From:
To: [DCAdmin](#)
Subject: Application number 2019/90501
Date: 21 March 2019 11:09:02

Ordnance Survey Plan

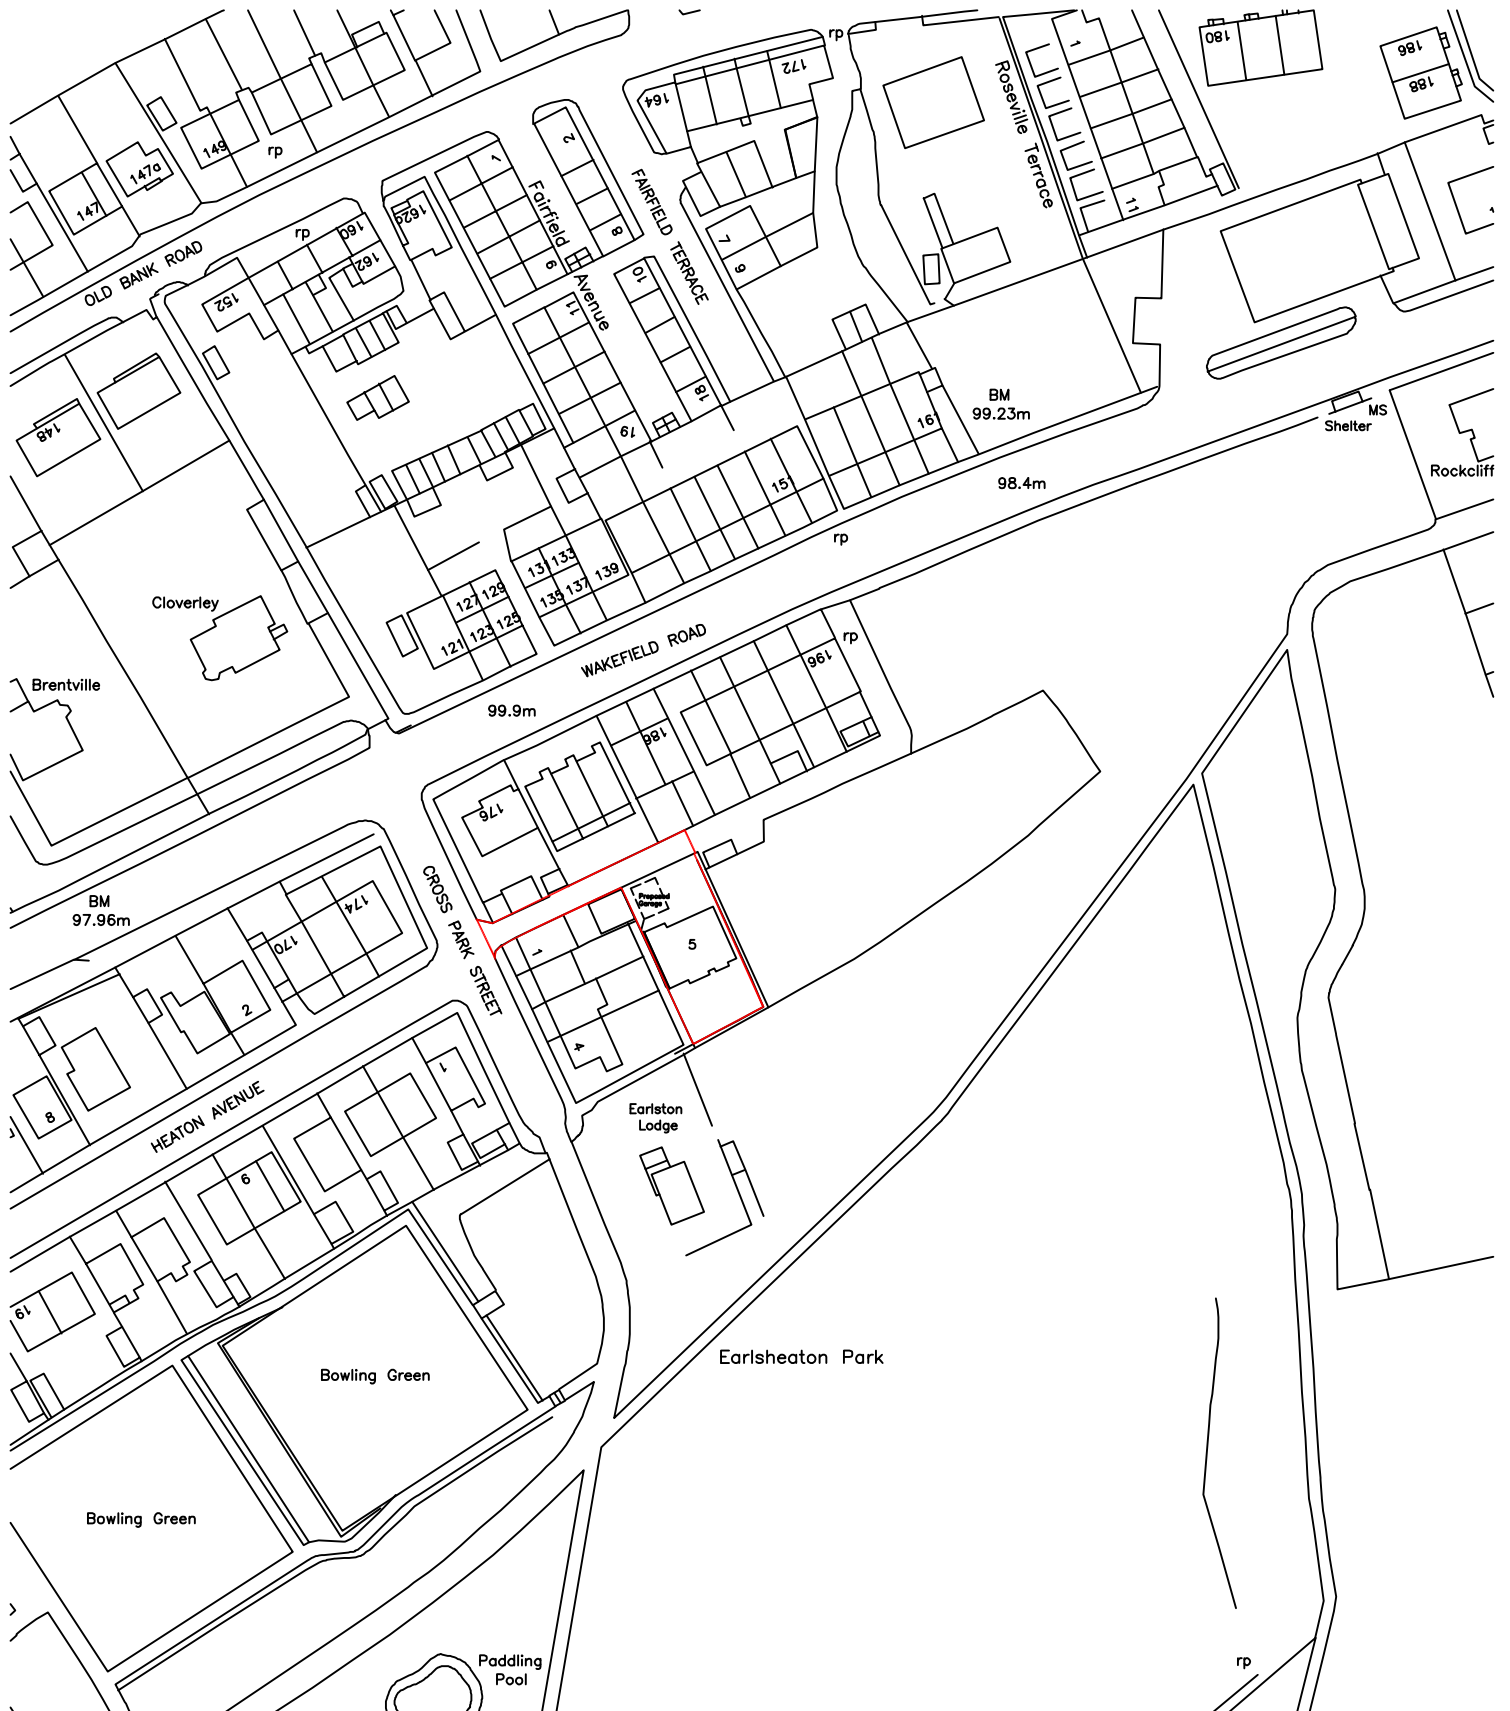
The maps and aerial view supporting this application are outdated. To make an informed decision all supporting documents should be current.

The aerial view is of the site proposed but does not show _____ and
feel this needs to be shown to correctly evaluate the application. The property as it stands is
_____ out of scale compared to other properties in the vicinity and feel further
development to this property will only add to this so accurate and up to date plans, drawings and
photographs are needed to assess the application correctly.
